7 January 2025

Re: Application for an Order Granting Development Consent for Stonestreet Green Solar – Comments on any further information/additional submissions received by Deadline 1

Typical Inverter Station
 Gravel Depth: 0.5
 Surface Area: 485m² (22m x 22m)
 Slope: 1:1000
 Porosity: 0.3
Hydrobrake Outflow Control
 Invert Level: 99.5mAOD
 Depth: 0.5m
 Design Flow: 0.4 l/s

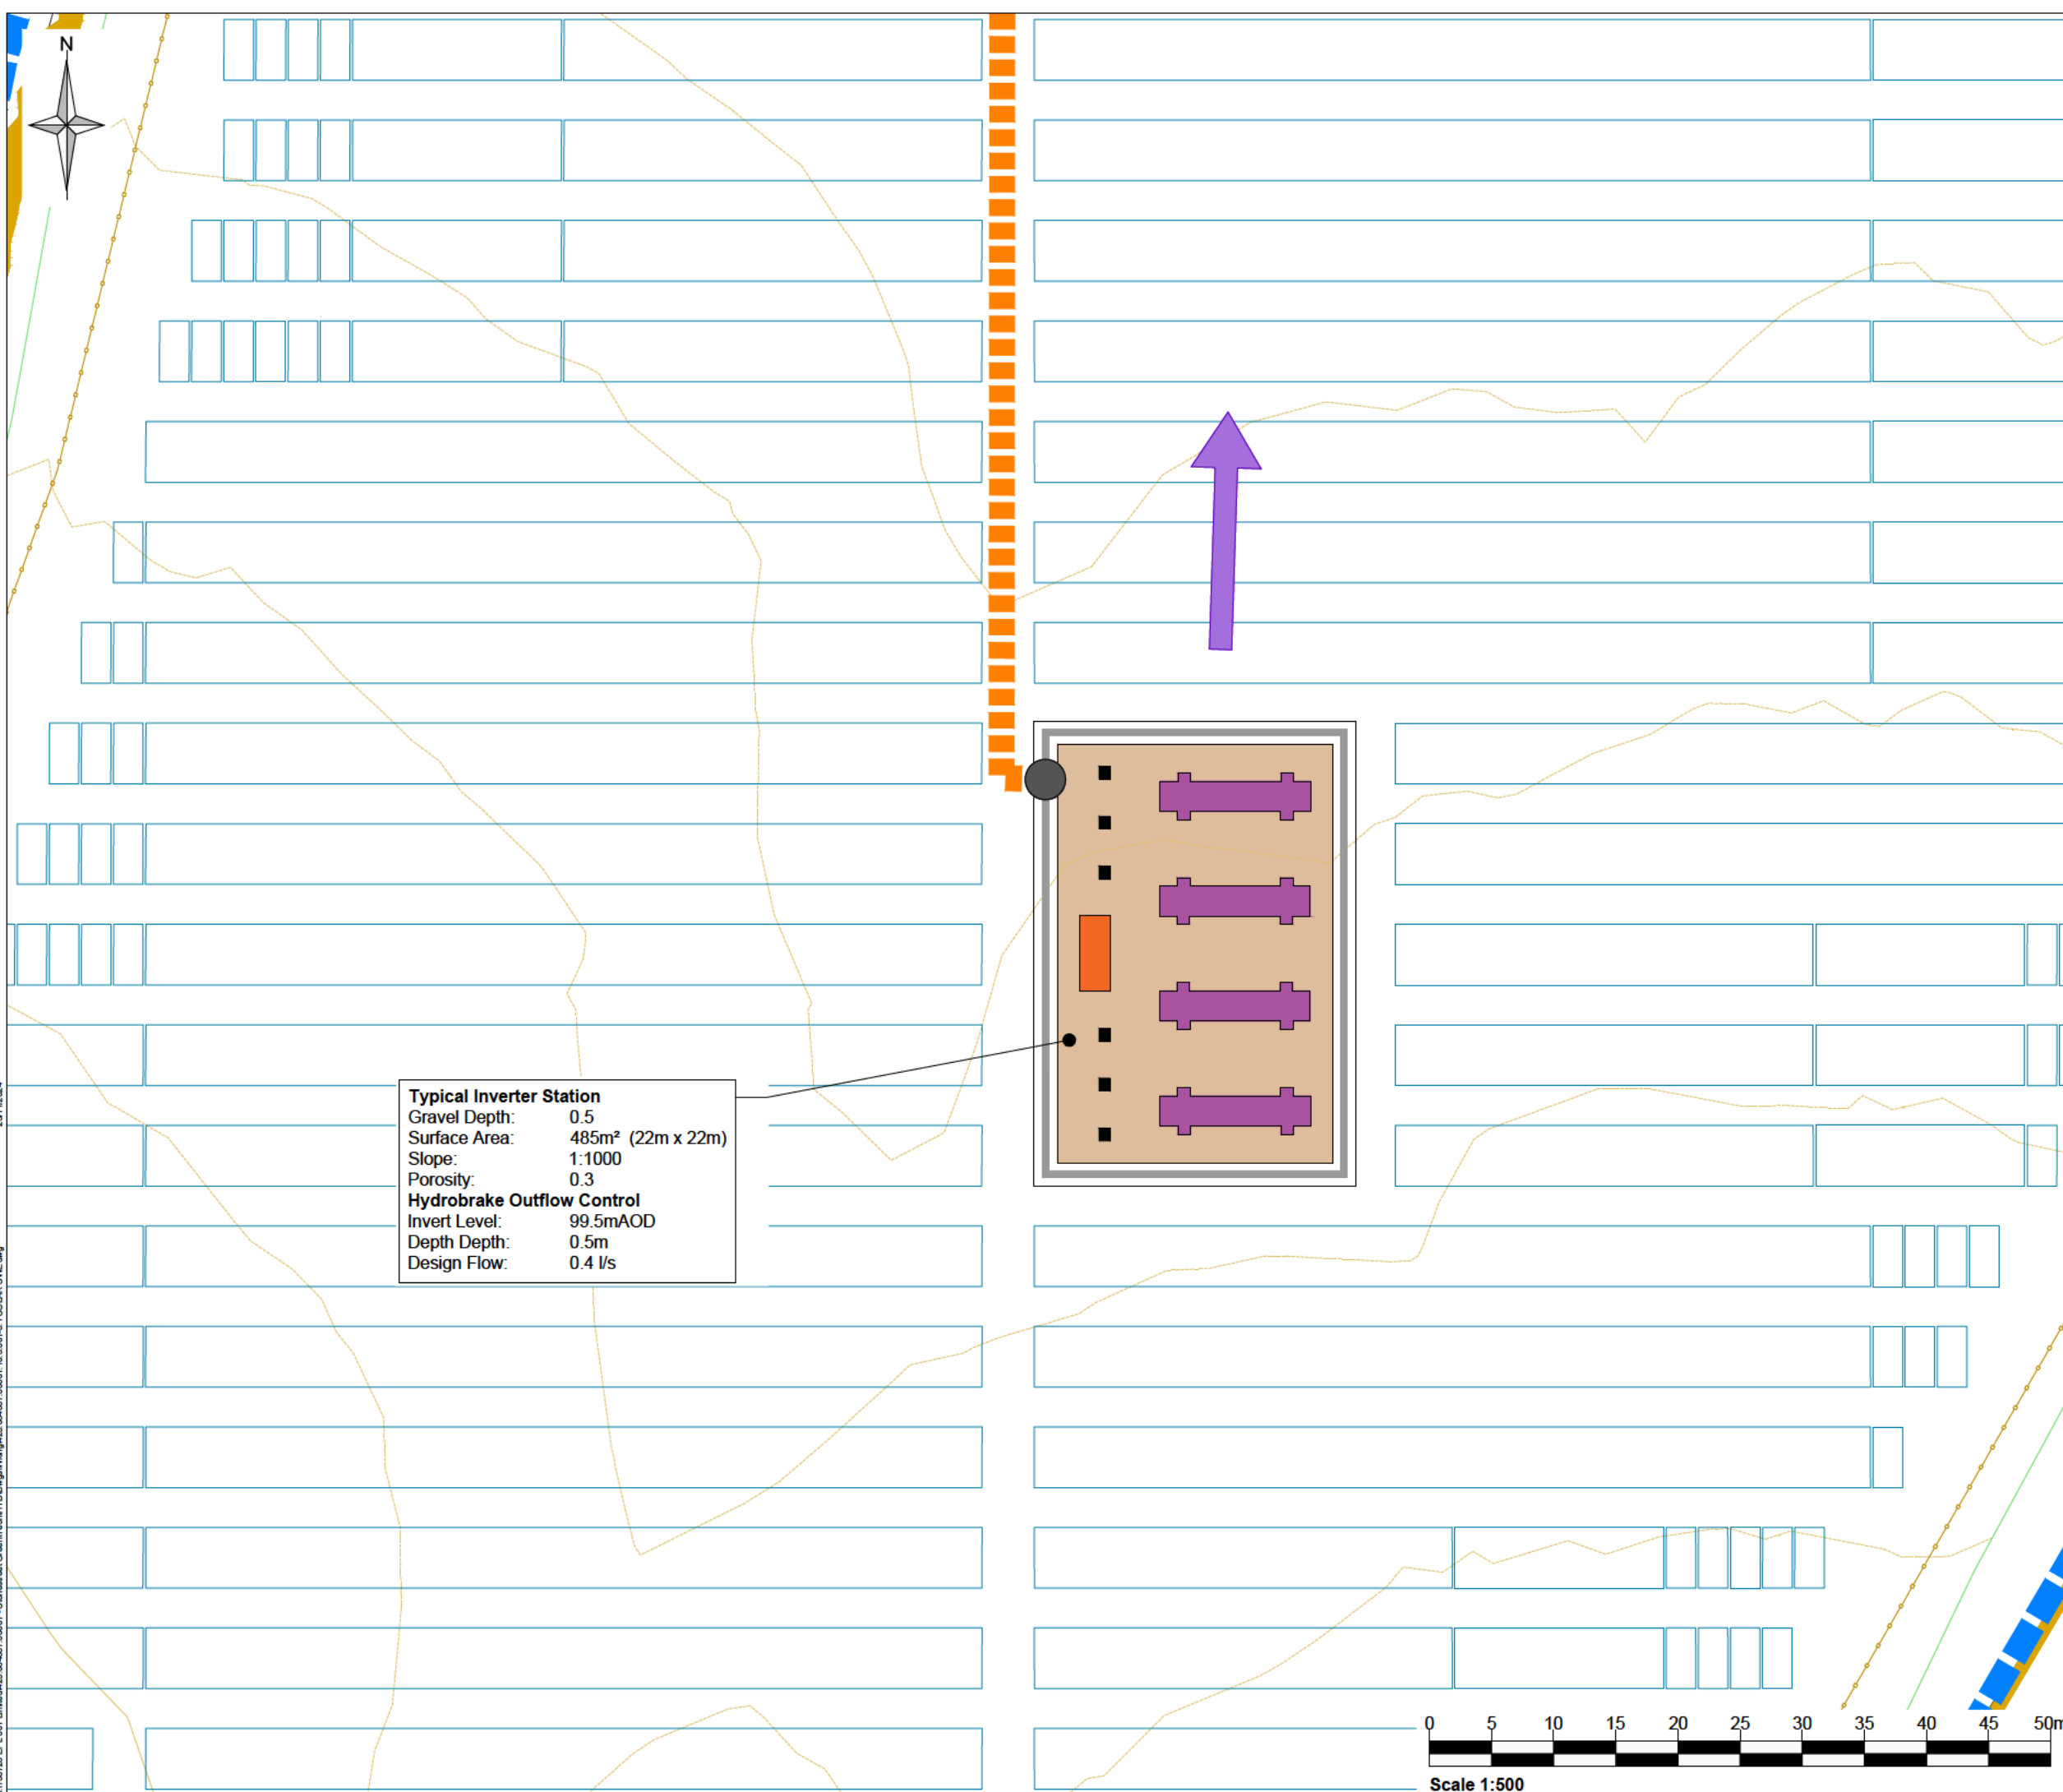
A similar issue applies with regards to the modelling undertaken in relation to the inverter stations; however on this occasion there is no proposal to line the permeable areas and they have been utilised in the greenfield runoff and hydraulic calculations in contravention to the above guidance taken from the Ciria SuDS design manual para 24.2.2. However, given that the discharges from the inverters are so small this adjustment should be easy to undertake as part of the detailed design going forward given the size of the red line boundary and the minimal additional volumes of water that will be required to be attenuated as result.
